Your Ref: OWPC15241
Our Ref: BR/194/17/PL 30-06-2017
Please ask for:
Richard Temple

Demolition of the existing Foreshore office & decommissioning of existing underground toilets. New purpose built unisex toilet block including urinals, baby changing facilities & accessible WC, plus a separate beach office with public information point & first aid facilities. All located on the existing seafront promenade.

Promenade Opposite Clarence Road The Esplanade Bognor Regis

OBJECTION TO B/194/17/PL

DRAWING
Proposed Toilet Elevations

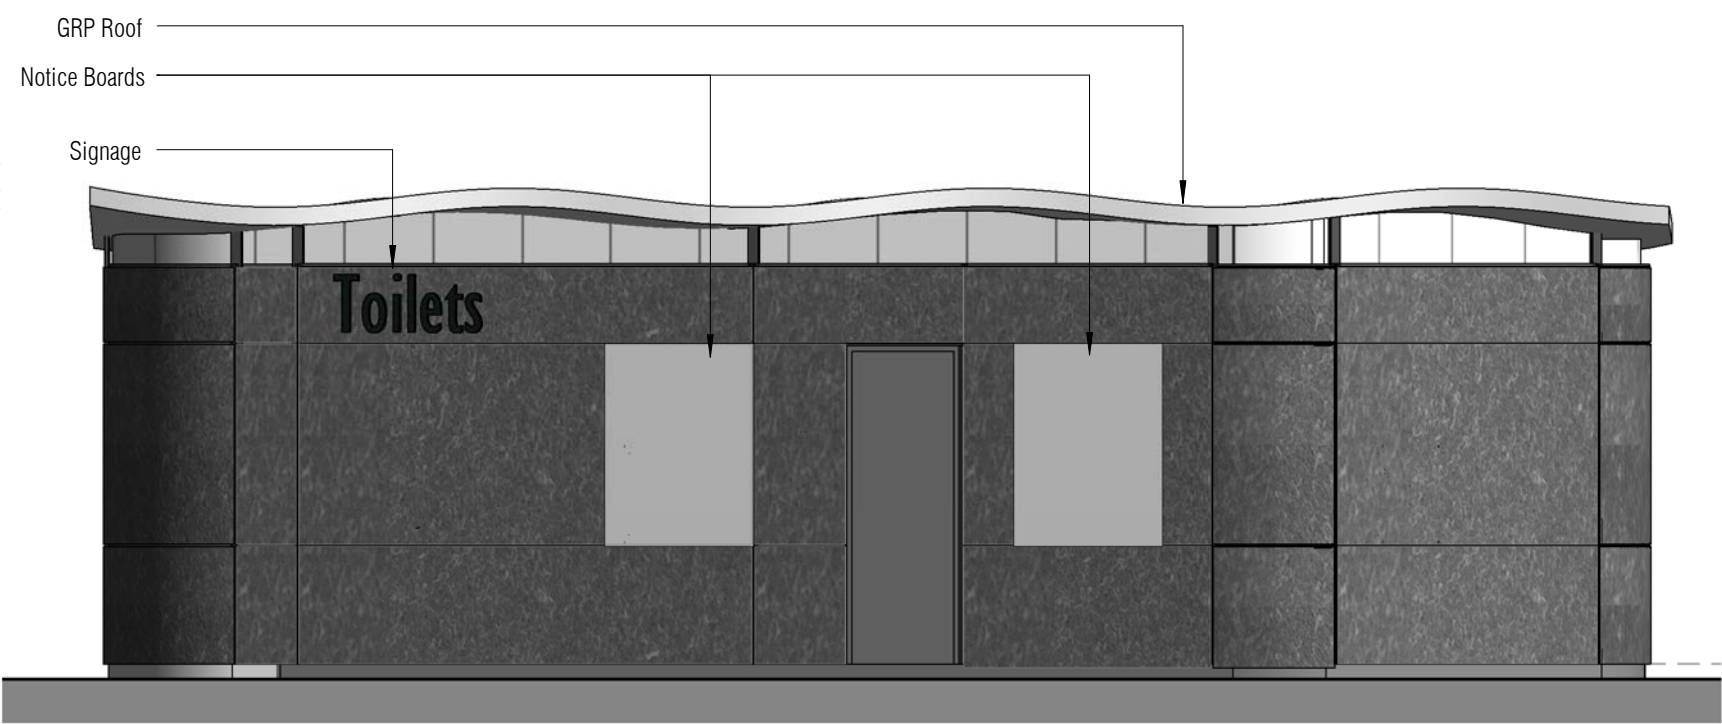
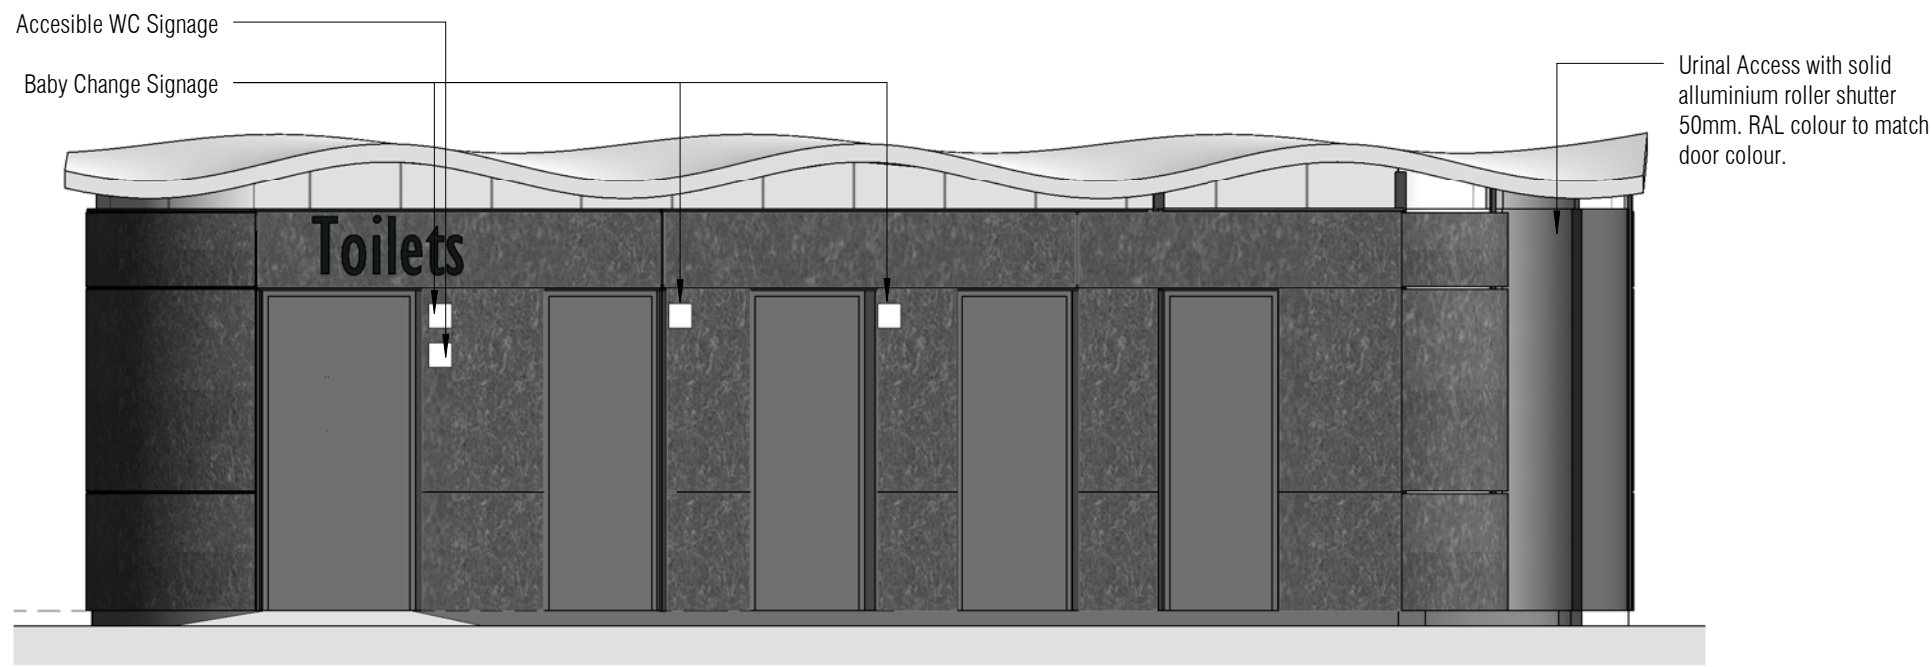
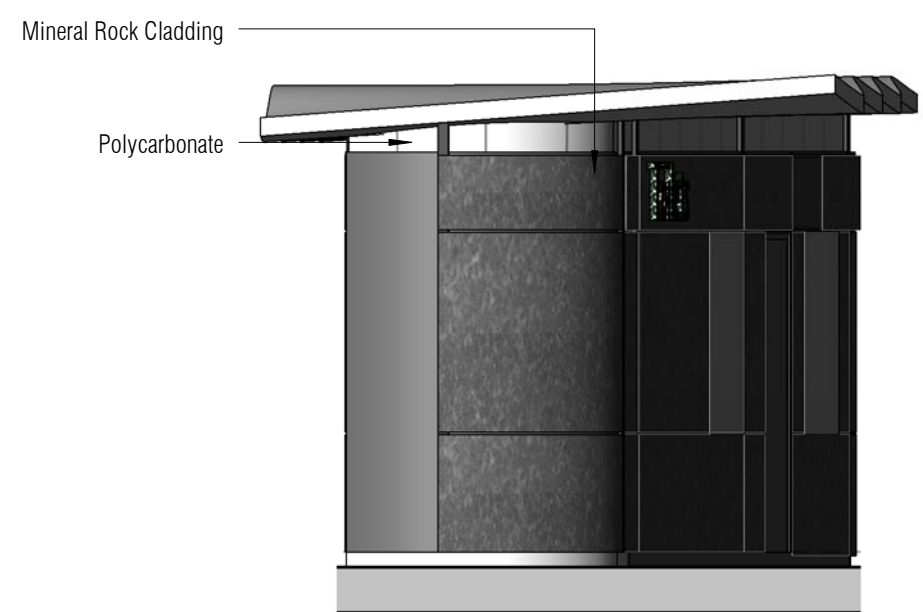
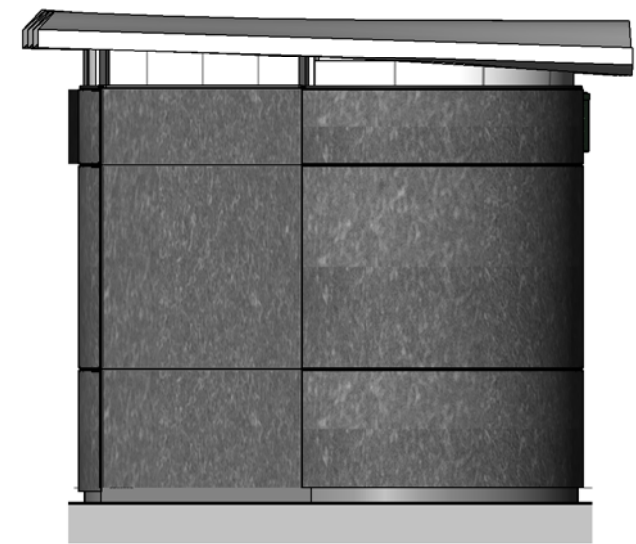
The toilet block design lacks public decency. Anywhere else I have ever been, a basic design requirement seems to have been to not have cubicle doors- never mind the WC's- open to the public's view- and straight on at that. To propose such a thing when there are passers by and residents' lounge windows and balconies just across the street beggars belief. Also, the layout drawing shows the distance between the urinals to be 660mm- about 2 feet. So using that for scaling from the drawing, it is also roughly the distance that a man turning round from the urinal has to cover before he is in the public view.
